16 December, 2016

Rankin Park to Jesmond Bypass - EIS

Figure 1 – My proposal for a shorter overpass for the West end connections to Jesmond Park

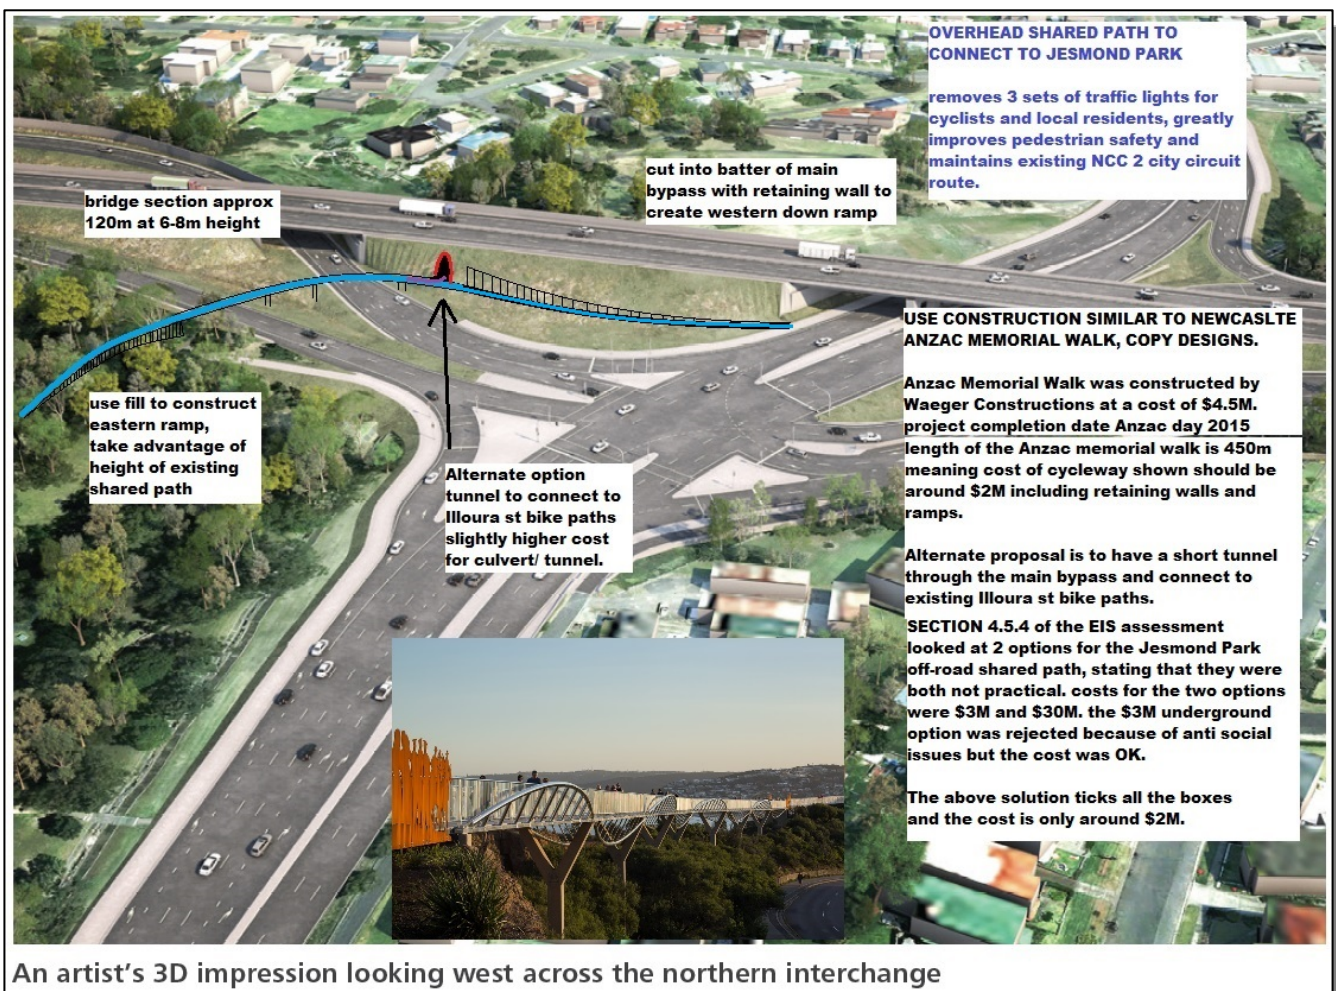
The present proposal for the Hospital Interchange includes a shared path on the northern side of the over bridge. This shared path then crosses the bypass exit ramp at an unprotected crossing. This crossing is unsafe and must be corrected. It is not acceptable to create new hazards. A simple test should be applied to this area:

At present the shared path the runs along the south side of Newcastle Road provides a safe and continuous Active Transport route. The present proposal breaks this continuity by having three signalised crossings. The Level of Service for riders and pedestrian would be greatly diminished as they wait for a green phase. There is no mention of Bicycle Lanterns on the crossing, and so under present NSW Rules, the bike riders would need to dismount and walk across the crossings.

Bicycle NSW and Newcastle and Newcastle Cycleway Movement have been briefed by RMS on a further option for this location, ie a bridge over the entry ramp combined with an underpass of the bypass. This has been called the "Underpass/Overpass" option, and option should be included in the final design.
